Subject: FW: Planning Consultation on: WA/24/21/DOC

Condition 3- surface water drainage design

Application No: WA/24/21/DOC

Site Address: Lower Farm Yapton Lane Walberton BN18 0AS

**PERMEABLE BLOCK PAVING YARD CONSTRUCTION
WITH VOIDED SUBBASE AND FILTER DRAIN**
(Scale 1:20)

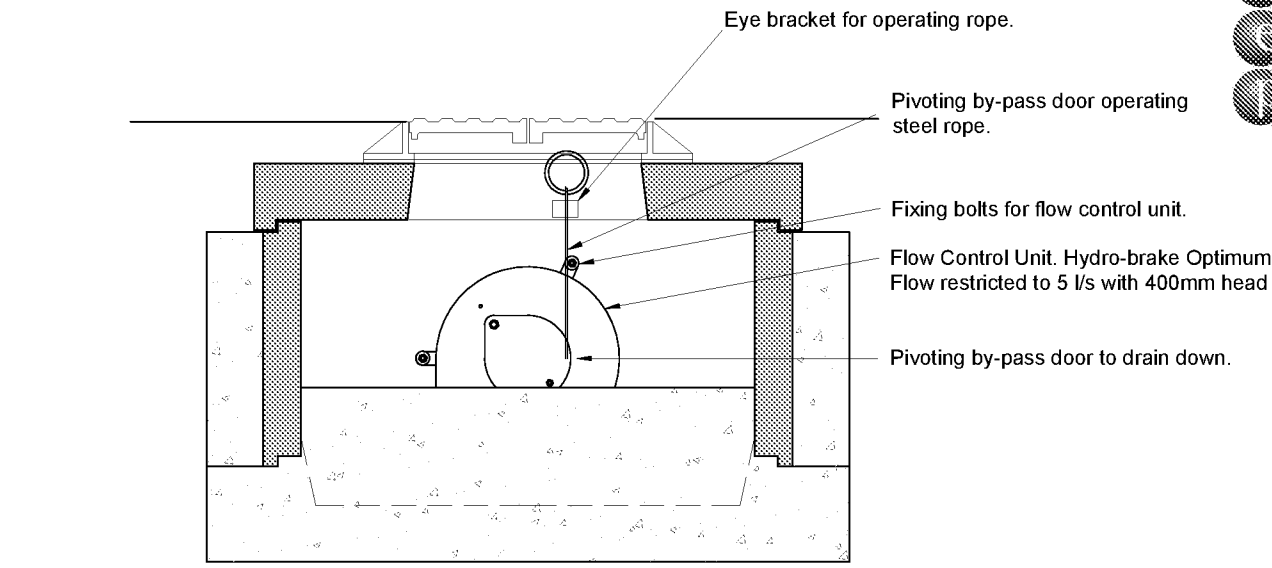
7. Finish and formation levels of permeable paving must be provided on plan.
8. Details of the proposed ditch need to be supplied, including proposed invert level, existing levels of the ditch, proposed connection invert level, long sections, cross sections.

HYDROBRAKE MANHOLE DETAIL
(Scale 1:20)

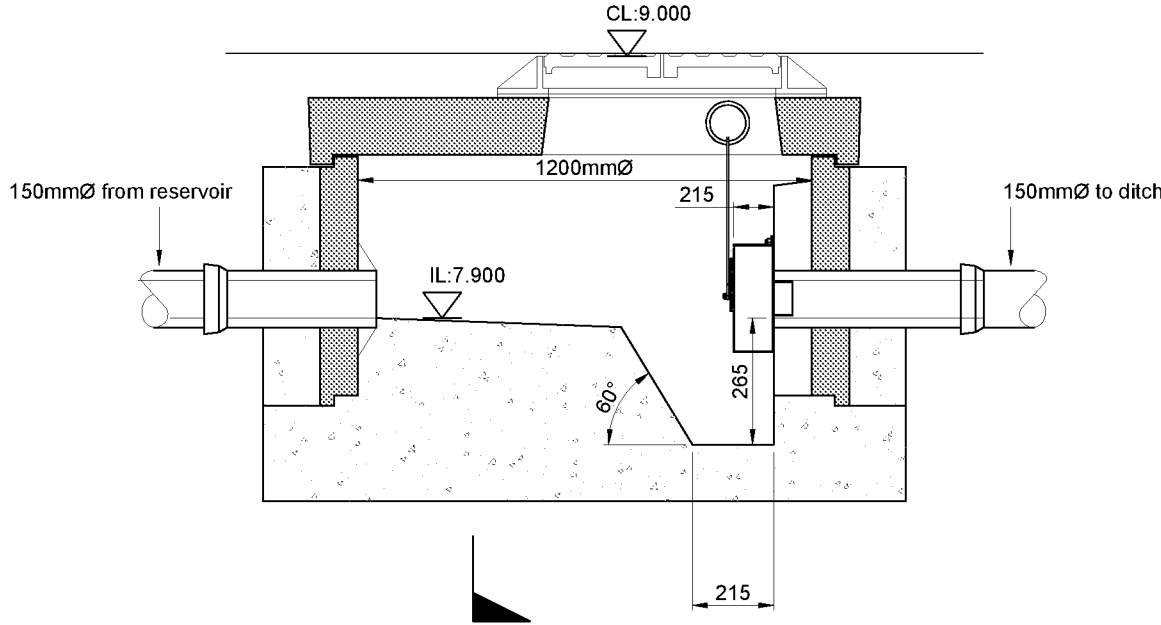
5. The construction detail of the hydrobrake needs to be updated to be consistent with layout and calculations.
6. The invert and cover level of the hydrobrake should be stated on plan.
